Our Case Number: ACP-324383-26

Re: Proposed IDA Belview Infrastructure Development
Belview, Slieverue, County Kilkenny

Re;Planning 324383

Title: **Proposed Access Road Layout Sheet 1 of 2**

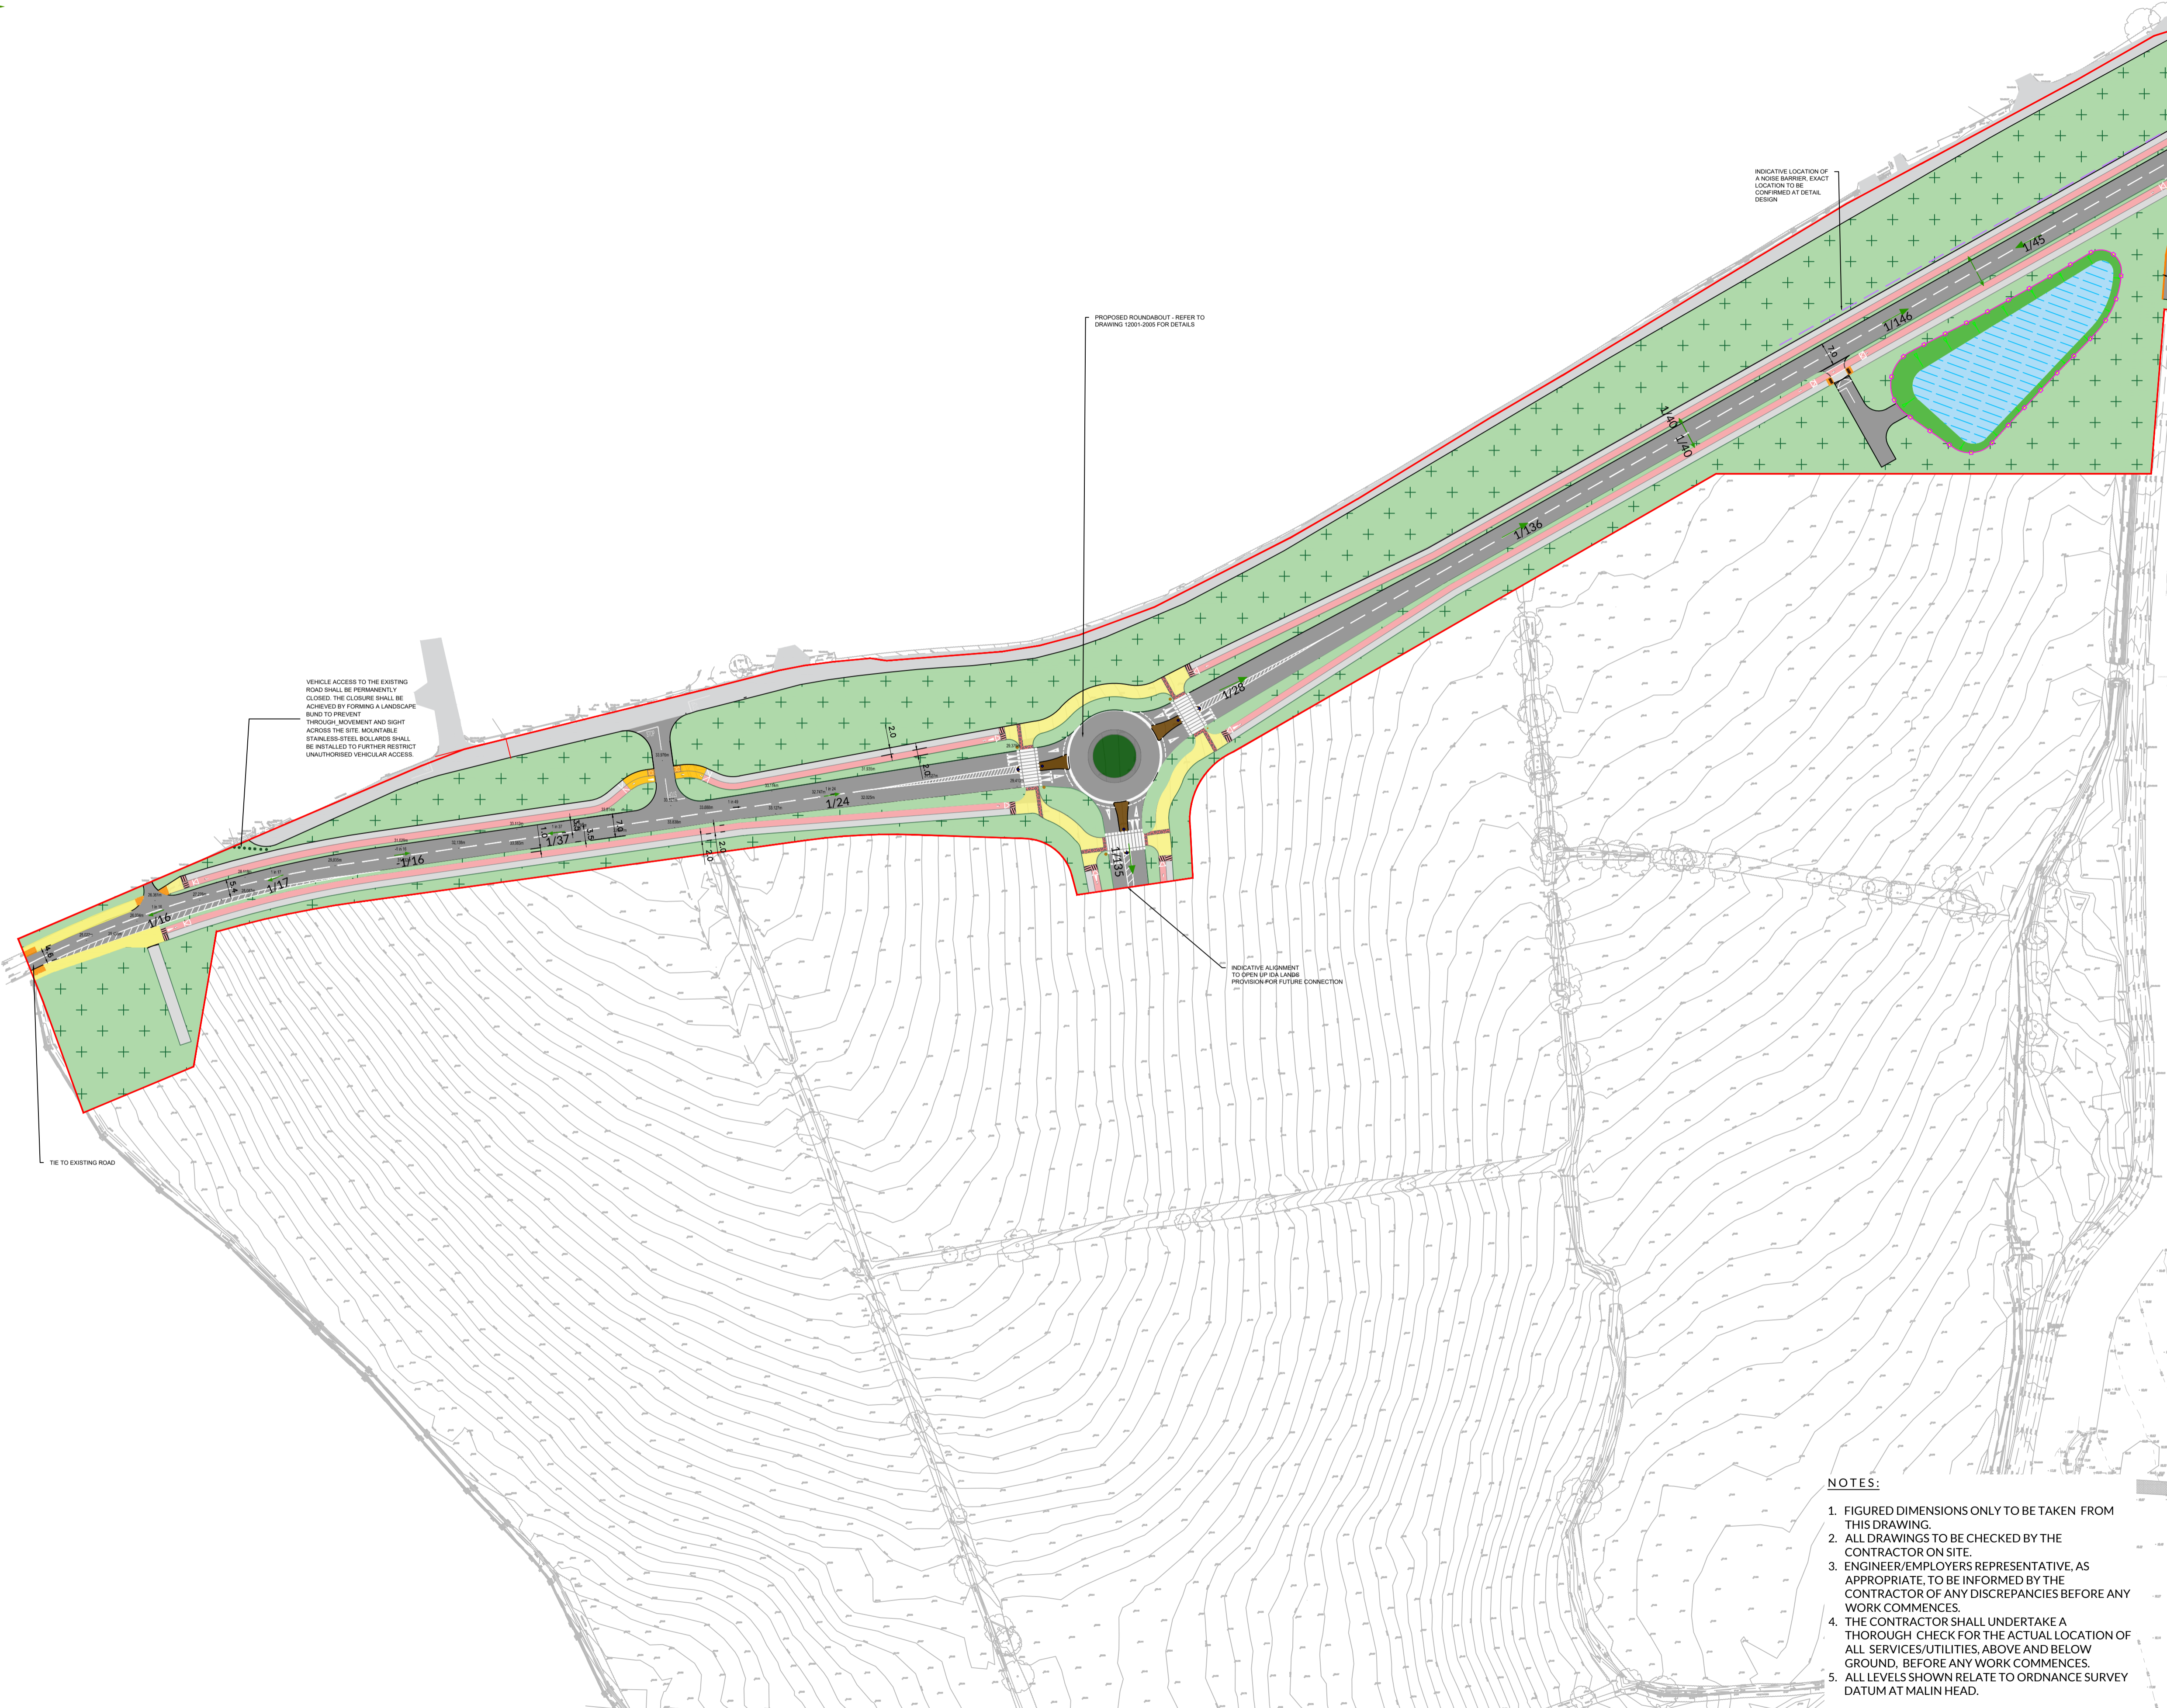
There appears to be three houses excluded from the noise impact study. That is Mannings, Roches and Kellys. Is there a reason for this? There are also no plans for any noise barriers to be implemented in this area. As it is we are suffering from noises at the Port.

The house X91 X8Y2 is cut off and on a new part of the road, which is unsafe and unnecessary.
